RE: University Credit Union, 1071 Brighton Avenue, Portland, ME

CBL: 274 -D-016 Application # 2006-0221

**VICINITY OF 1071 BRIGHTON AVENUE  
CONDITIONAL USE AND SITE PLAN REVIEW**

Shukria Wiar, Planner  
Barbara Barhydt,  
Development Review Services Manager  
March 22, 2007

B-4 VINYL LOGO
 First surface applied translucent vinyl to match PMS 2748 & PMS 115

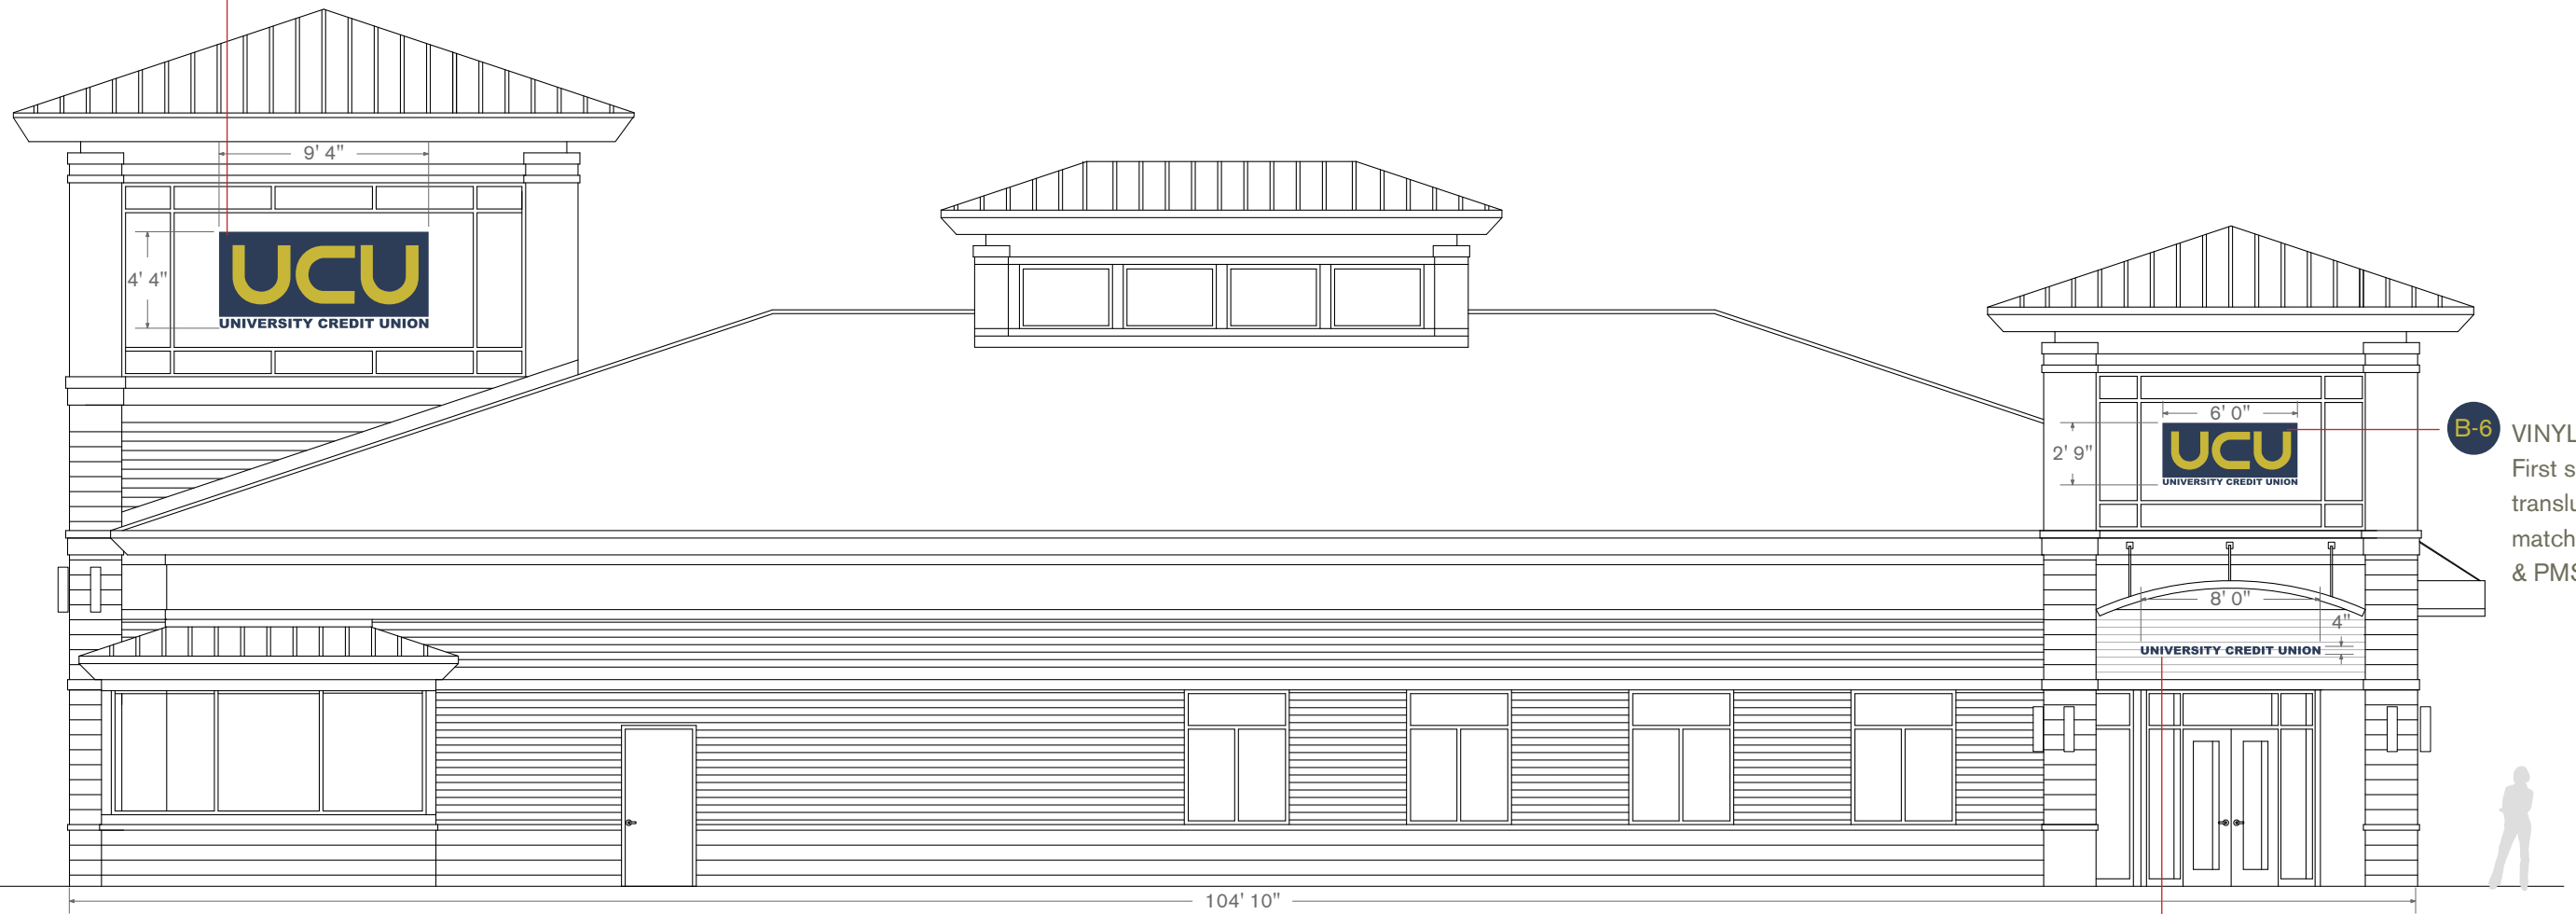
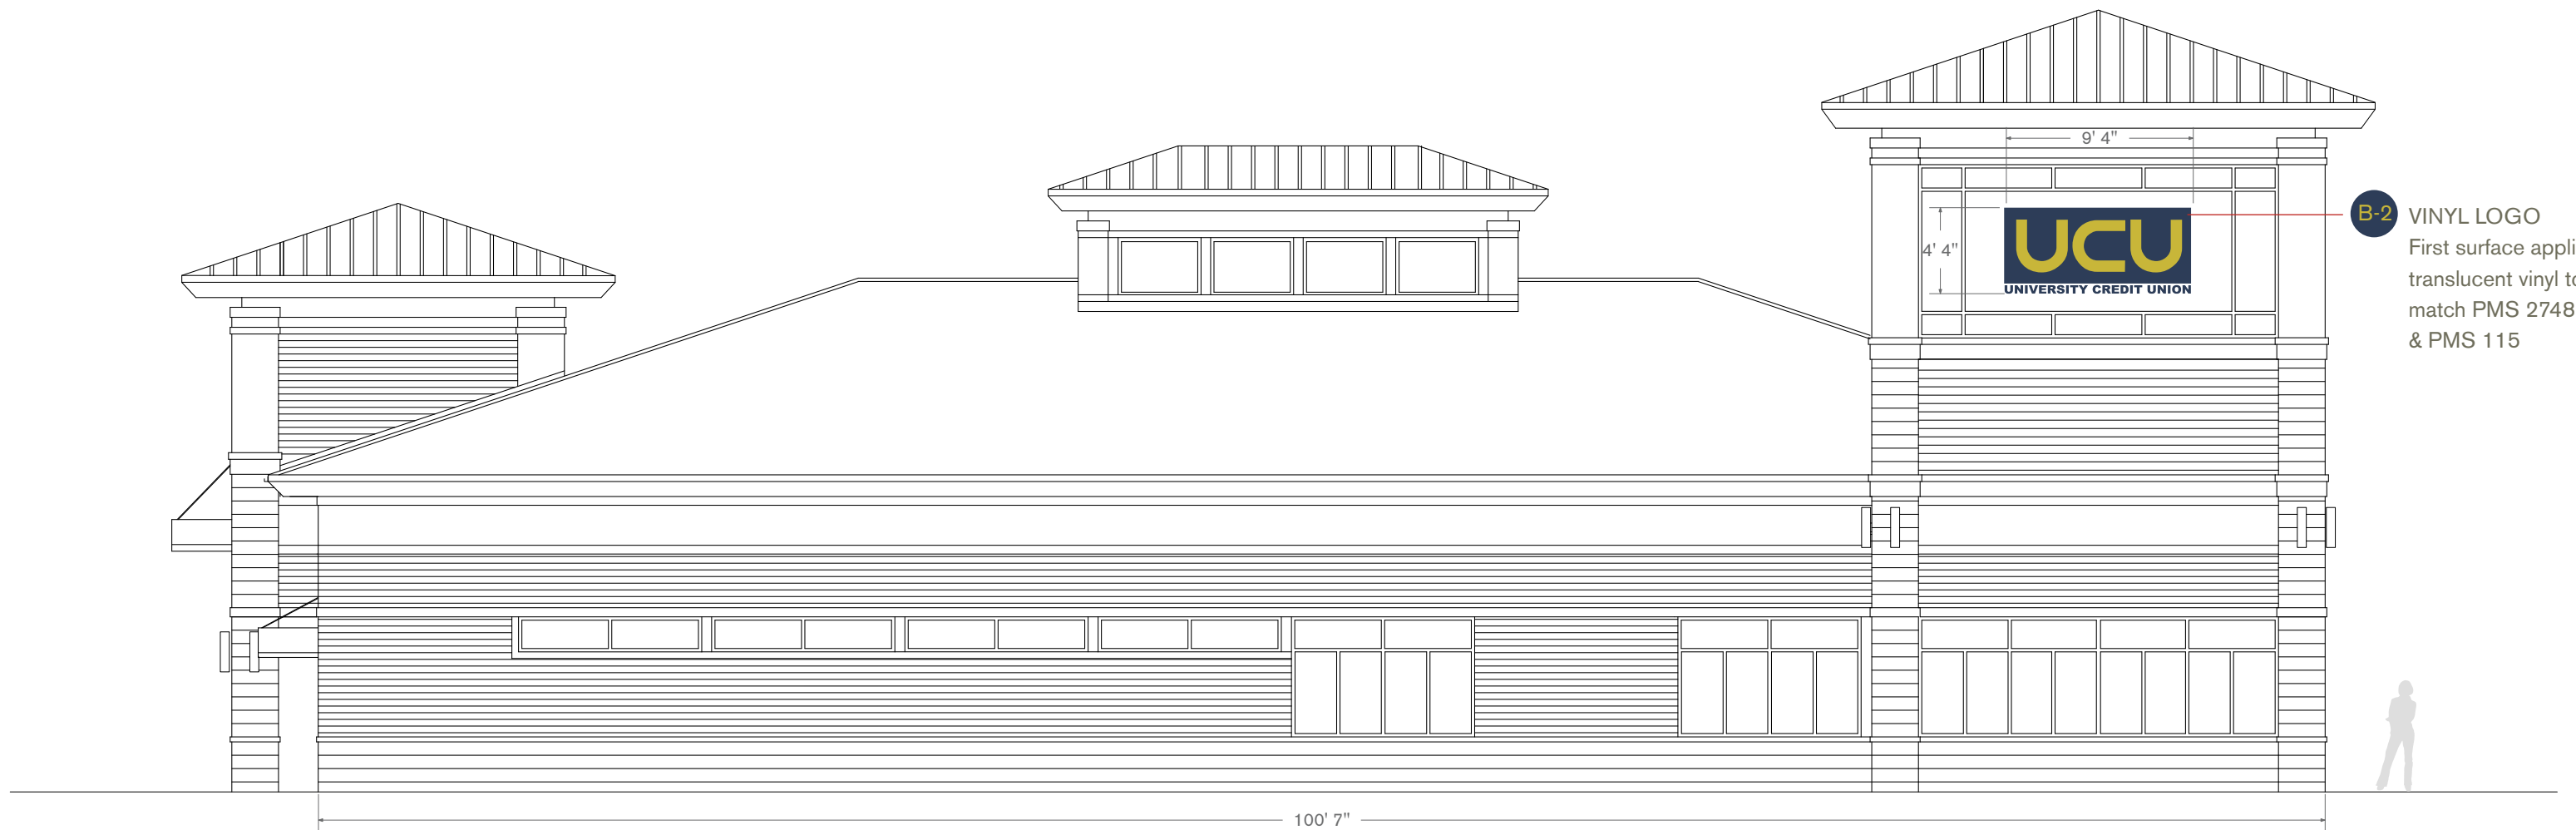
The signage plan is included as Attachment #21. Three-dimensional back-lit letters are proposed for the rotunda. The blue letters are 1' 5" high and 4" wide, which create a signage band above the rotunda's storefront windows measuring 28 square feet. The initials, UCU, are shown as three-dimensional back lit letters in gold on the East Elevation (facing side parking lot) and the West Elevation (facing Taft Avenue). Each of these signs is 9 square feet in total area. An entrance sign is proposed along Taft Avenue using the proposed building materials to create a planter base and an internally illuminated sign is proposed that has a total area of 27 square feet per side.

Three directional signs are shown on the site and all of the signs are located on the applicant's property. The directional signs are shown in Attachment #21. The sign panels are blue with white lettering and a gold ban. The posts and arch are silver and the base panels are a light gray.

The proposed signs do not adversely affect visibility at intersections or access drives and the signs advertise only the services offered on the premises. Refer to the Site Plan Review (Section VII, subsection 12) for further discussion of the proposed signs for the project.

- i. The infrastructure contribution of \$22,700 for the Brighton Avenue Street improvements shall be submitted prior to the issuance of a building permit.
- ii. The proposed sign dated March 12, 2007 meet the B-2 zone and the site plan standard for signs, Sec. 14-525 (22); however, separate sign permits must be obtained from the Inspections Division prior to installation.
- iii. The applicant shall submit sewer and water capacity letters prior to the issuance of a building permit.
- iv. The lighting fixtures shall be reviewed and approved by the City's Urban Designer prior to issuance of a building permit.
- v. The applicant shall work with Carrie Marsh, Urban Designer on the use of EIFS on the exterior of the building, particularly at the pedestrian level, prior to the issuance of a building permit.
